**RE: Urban Design Review Panel Report – 77 Metcalfe Street**

77 Metcalfe Street  
Response to UDRP Recommendations  
Site Plan Control Application

ELEVATION - WEST (METCALFE)
1:150

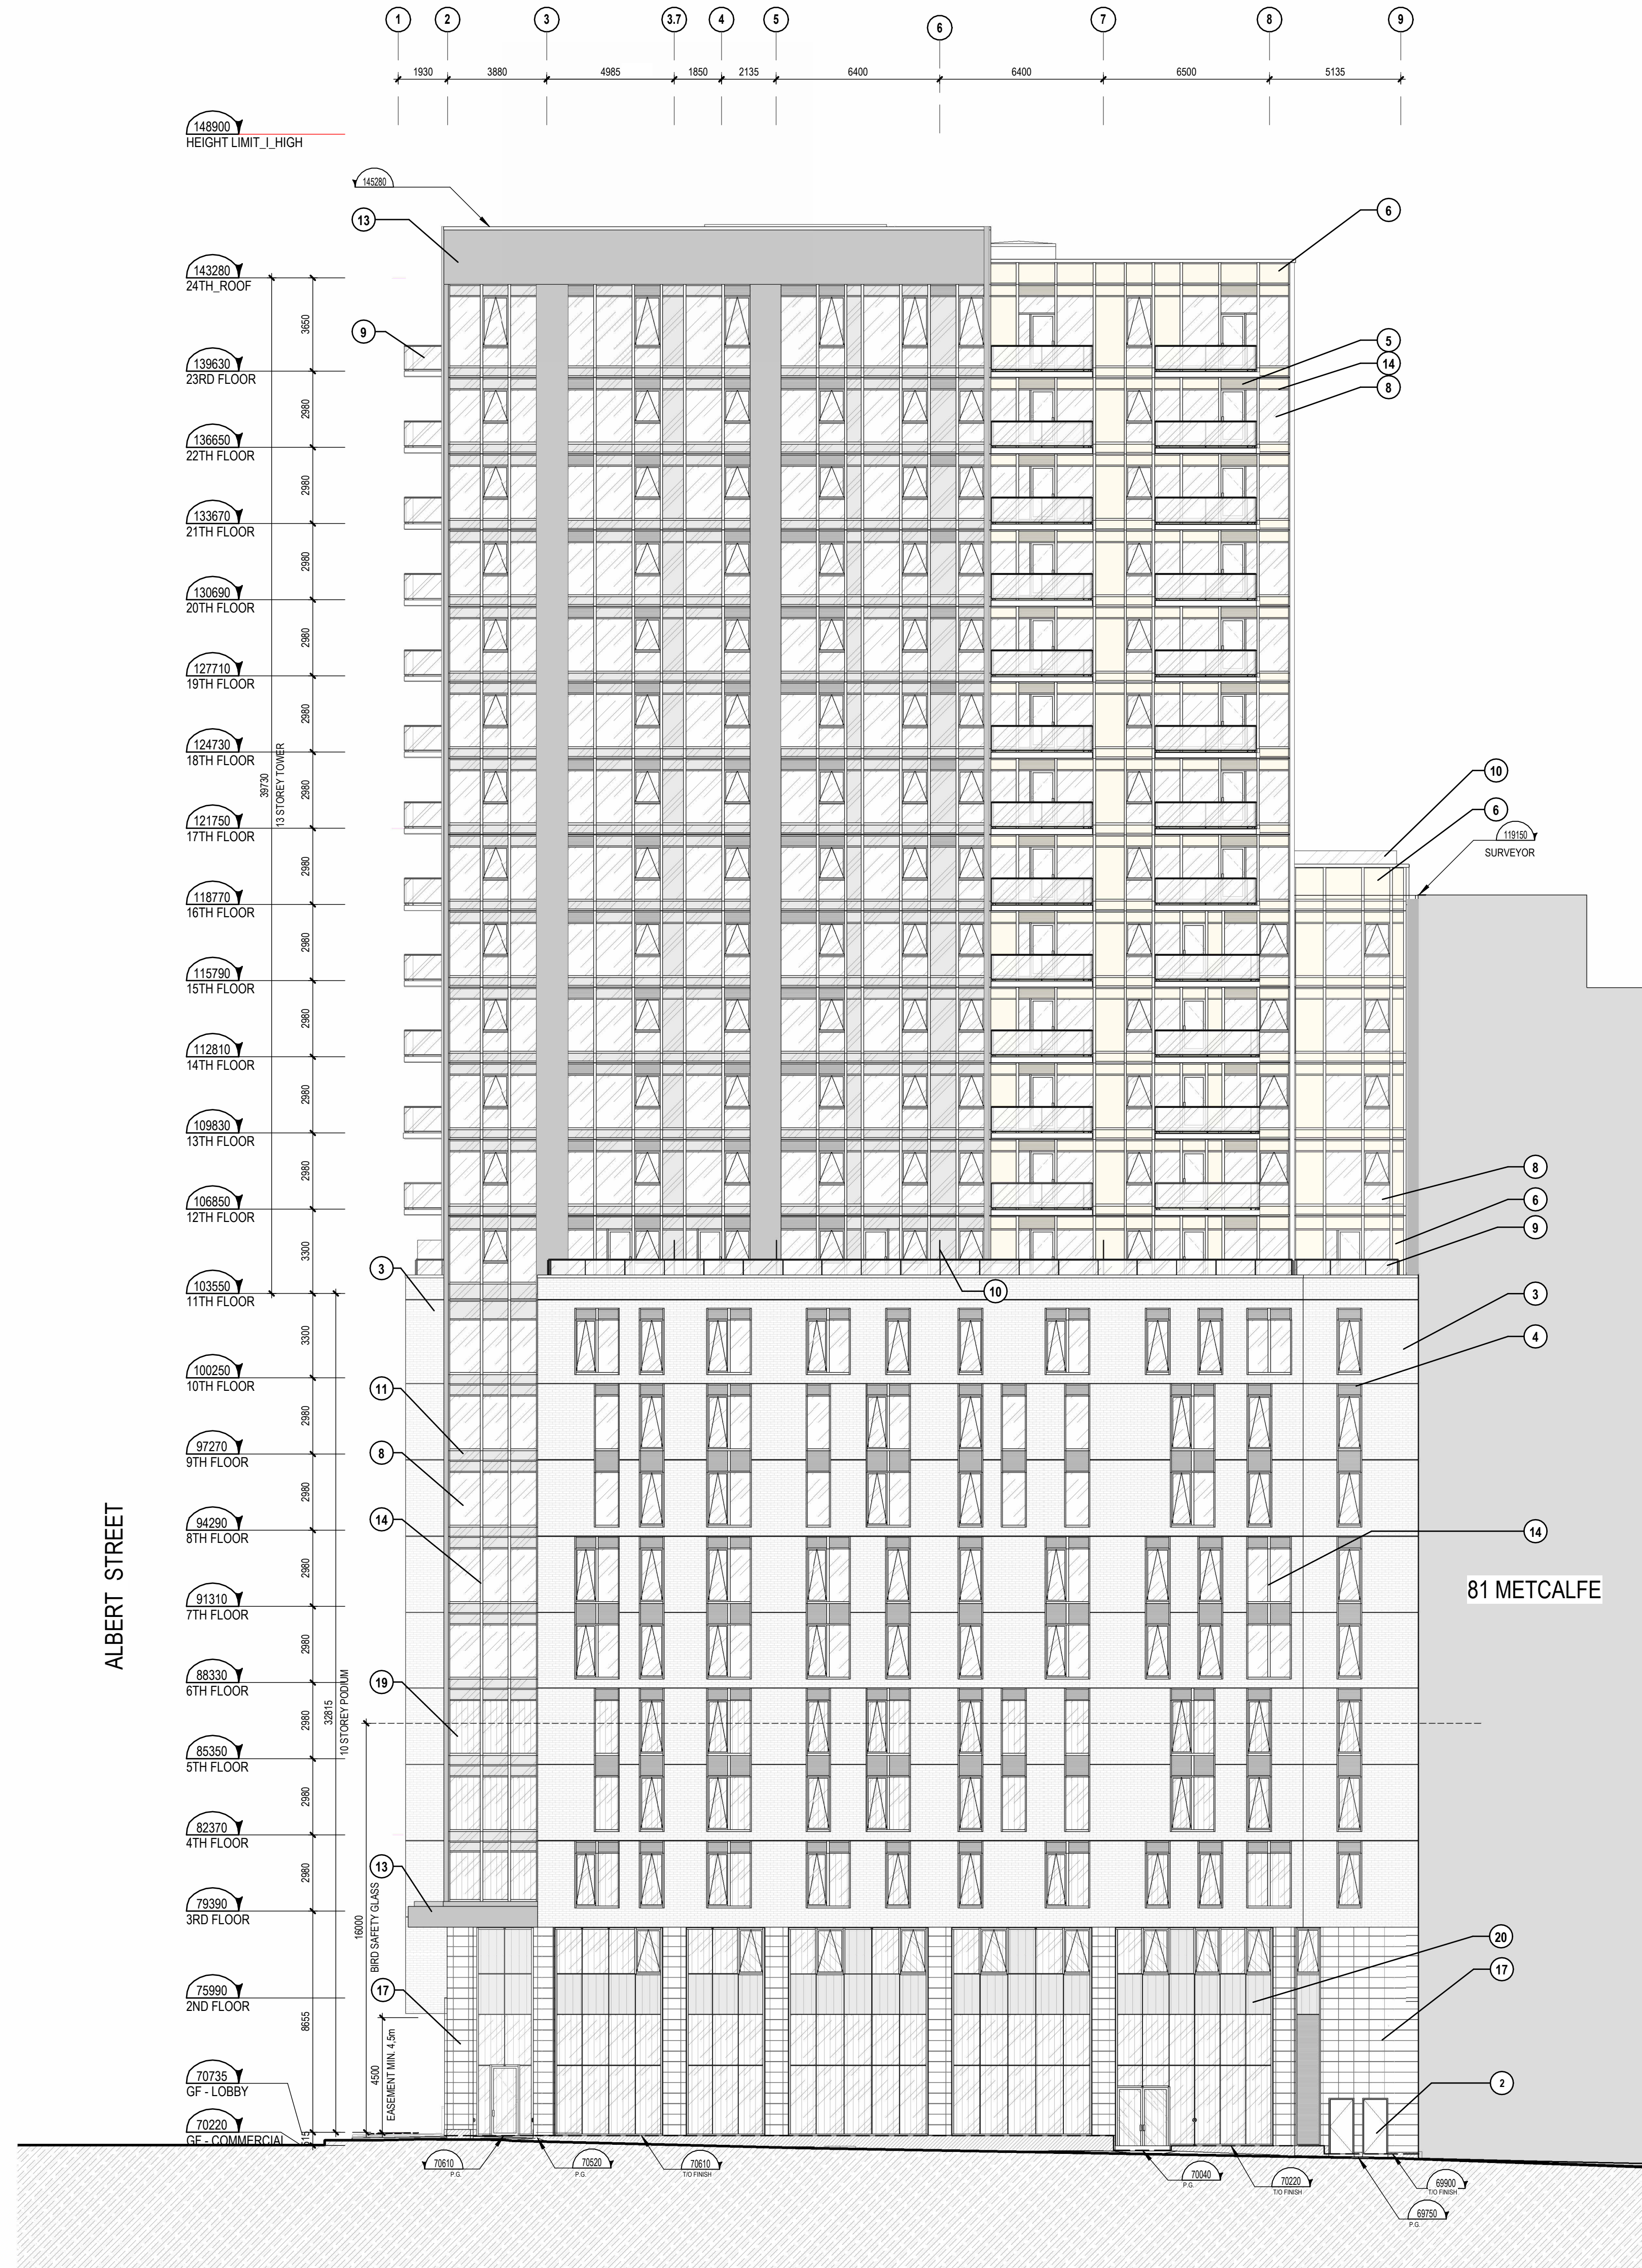
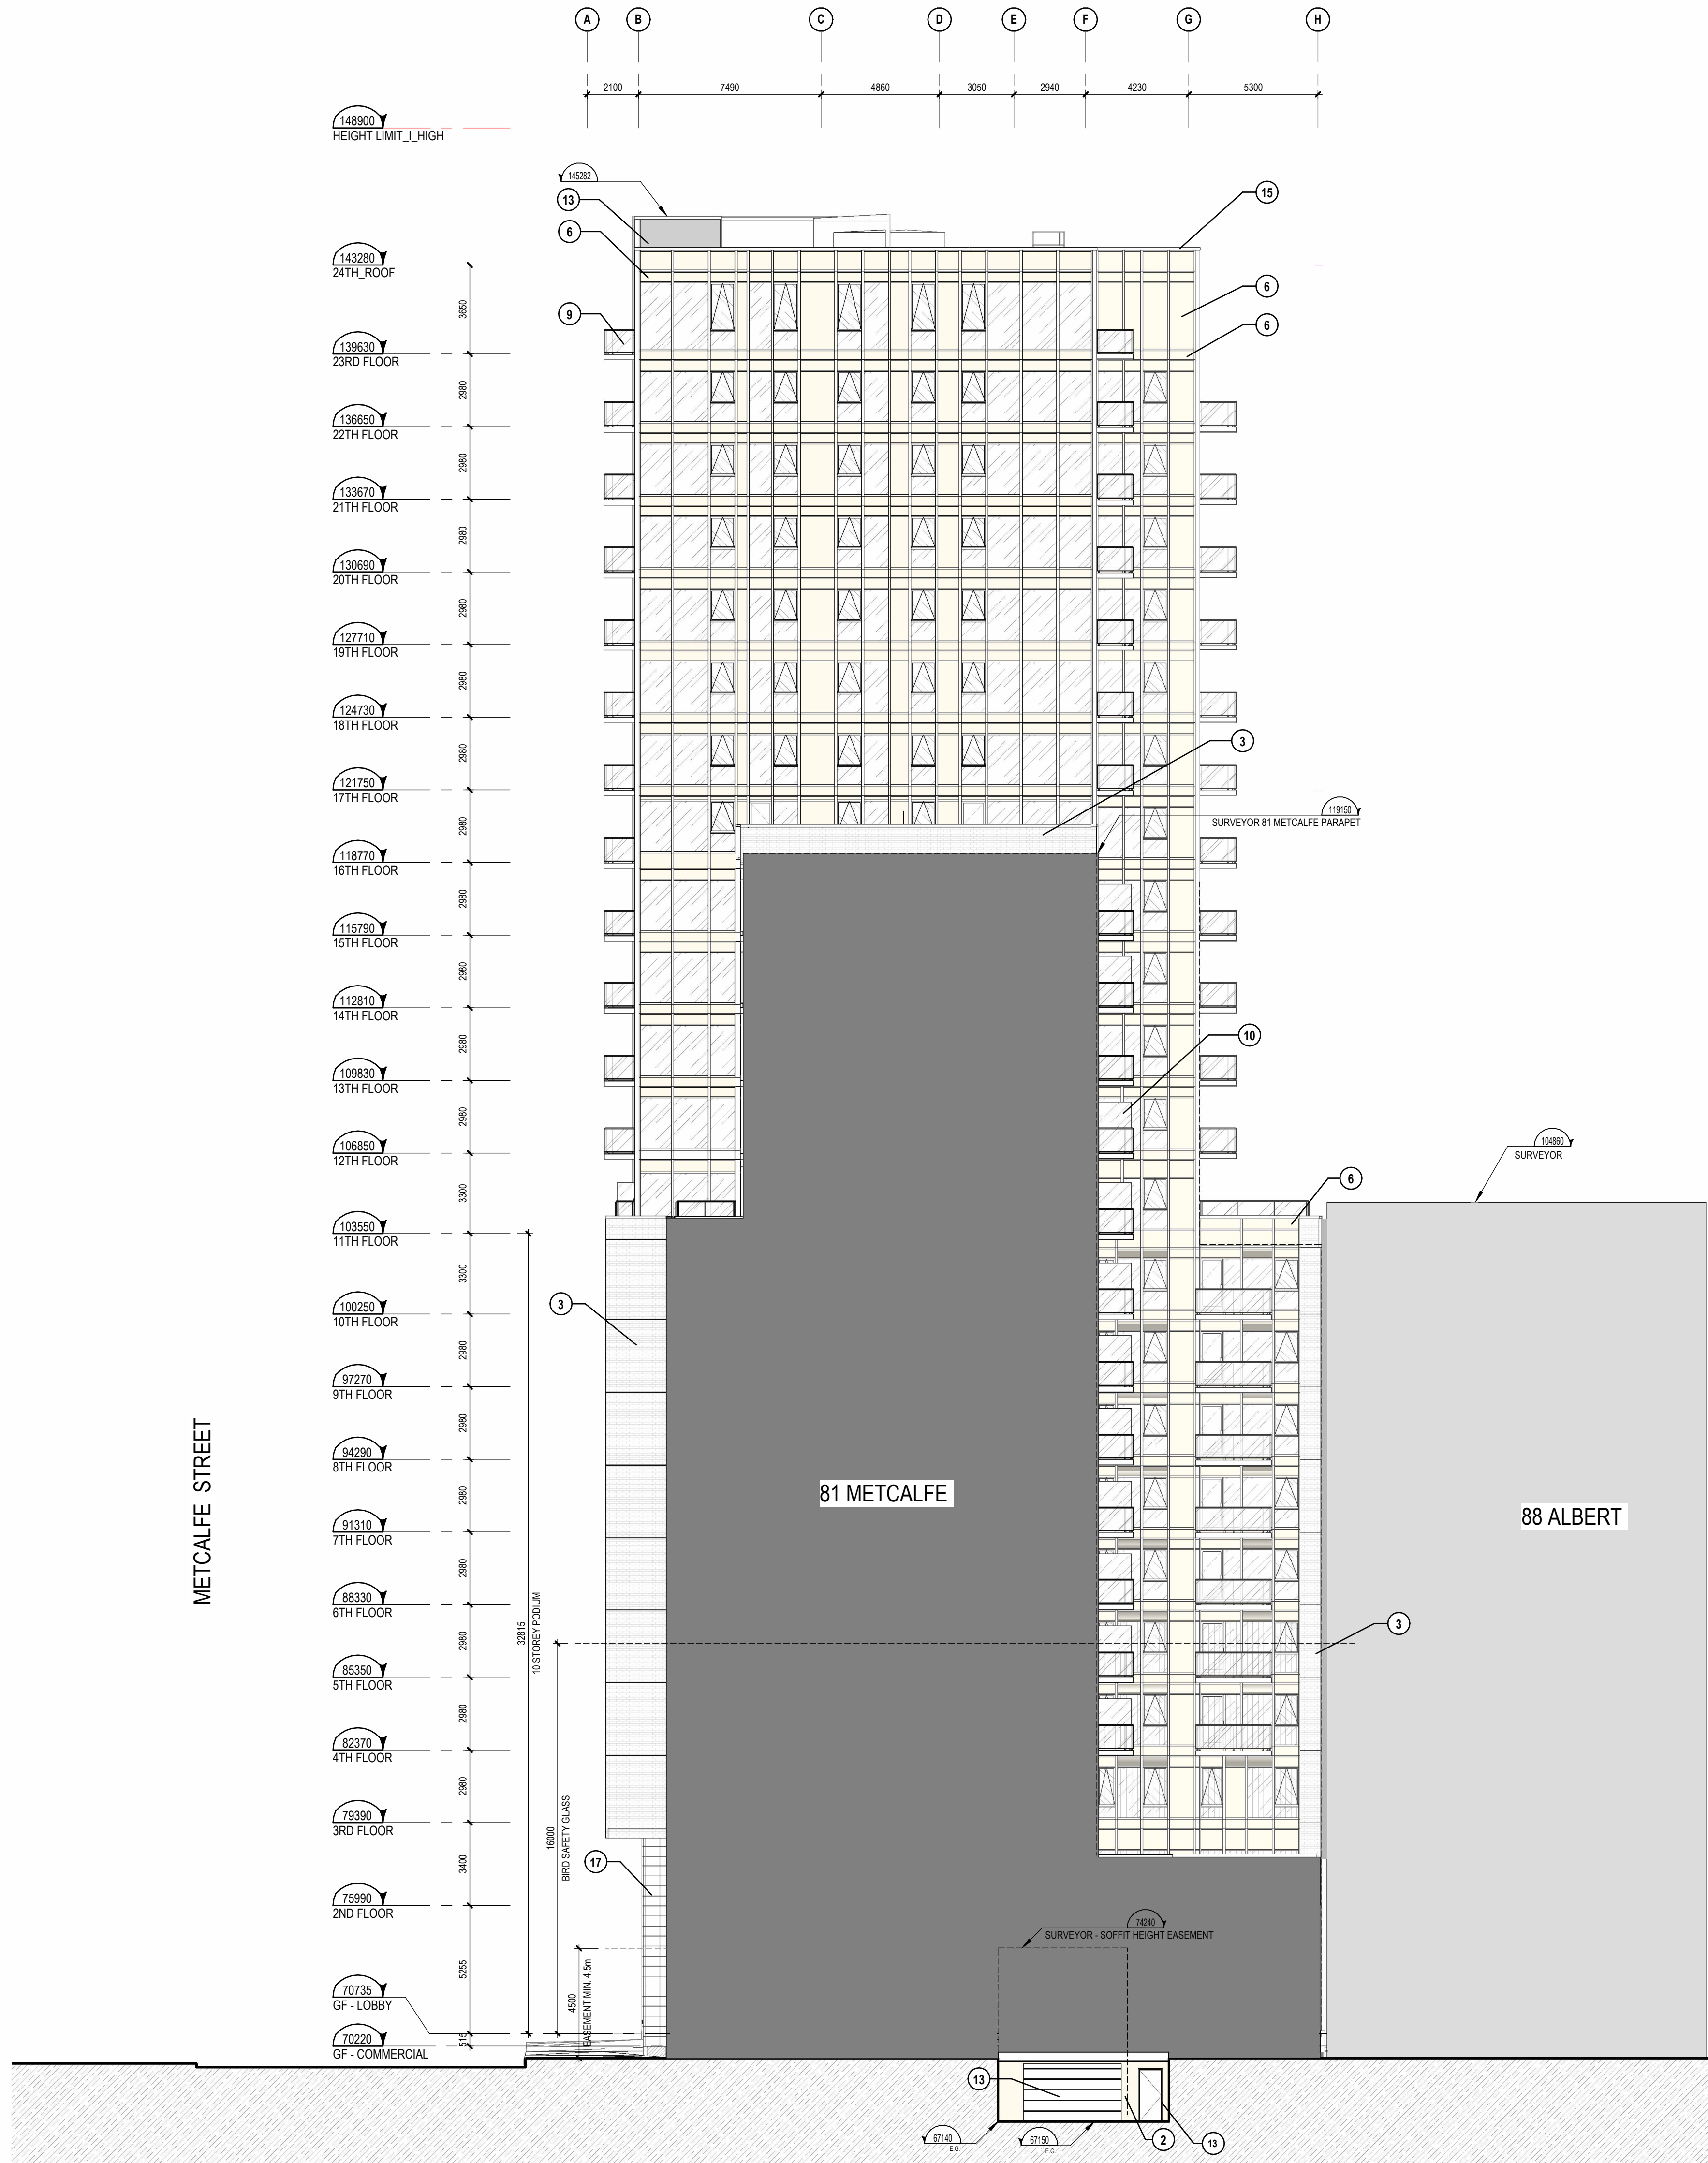
3.2	The cantilever design of the building at street level is a key feature, and the Panel suggests elevating it to enhance the pedestrian experience. A one-floor increase in height would allow for better clearance and a more luxurious feeling of space.	The soffit along the main frontage on Metcalfe has been elevated to reinforce a sense of openness and scale, enhancing the pedestrian passage. The granite cladding on the columns will serve as a prominent architectural element, providing a refined and tactile interface at street level, directly engaging with users and enriching the urban fabric.
4	The Panel recommends using noble materials for the podium base and encourages simplifying the volume expression.	The expression of the podium base has been refined by removing the black portion at its base, resulting in a more cohesive and streamlined design. Similarly, the tower’s expression has been simplified, adopting the light-colored finish of the podium to ensure a harmonious integration within a soft, cohesive palette. In response to the Panel’s recommendation regarding noble materials, light-colored granite will be incorporated at the ground level.

7.1	The Panel recommends raising the soffit height by one floor to improve the sidewalk experience and create a more comfortable pedestrian environment.	Indeed, the soffit has been raised to a height of two stories along the entire length of Metcalfe and above the main entrance, reinforcing the hierarchy of the streets and enhancing the pedestrian experience.

7.2	The use of the ground-level darker materials should be reconsidered, as it may not enhance the pedestrian realm experience. Lighter, warmer tones, possibly using more durable materials, will provide a more welcoming atmosphere.	The darker portion at the podium, on the second level, has been removed as per the recommendation and light-colored granite will be installed at the ground level.
Sustainability		
8	The Panel supports the idea of reducing the environmental impact of the project, particularly regarding the retention of the existing building. While it may not be feasible to keep the entire structure, the Panel recommends further exploring ways to reduce the carbon footprint of the project, including keeping portions of the building where possible.	Project aims to obtain LEED certification. Group MACH considered retaining the existing building but found the conversion costs were prohibitive in making the project financially viable.

11.3	The metal panel finishes at the ground floor level should be replaced with masonry to improve durability and to enhance the pedestrian realm experience.	The metal panel finishes at the ground floor level will be replaced with light-colored granite.
12	The Panel supports the idea of a more unified simplified architectural expression, above the base, particularly in the tower's massing. Simplifying the three-element materials tower design to two components would create a more cohesive look.	The podium has been simplified with a lighter color palette, aligning with the tower's design. The tower itself has been simplified by harmonizing the upper portion with a soft cream color, drawing inspiration from the podium's tones. Additionally, the central tower volume has been refined by emphasizing the vertical separation between the base and the top, with the lower portion raised to enhance the overall cohesiveness of the massing.
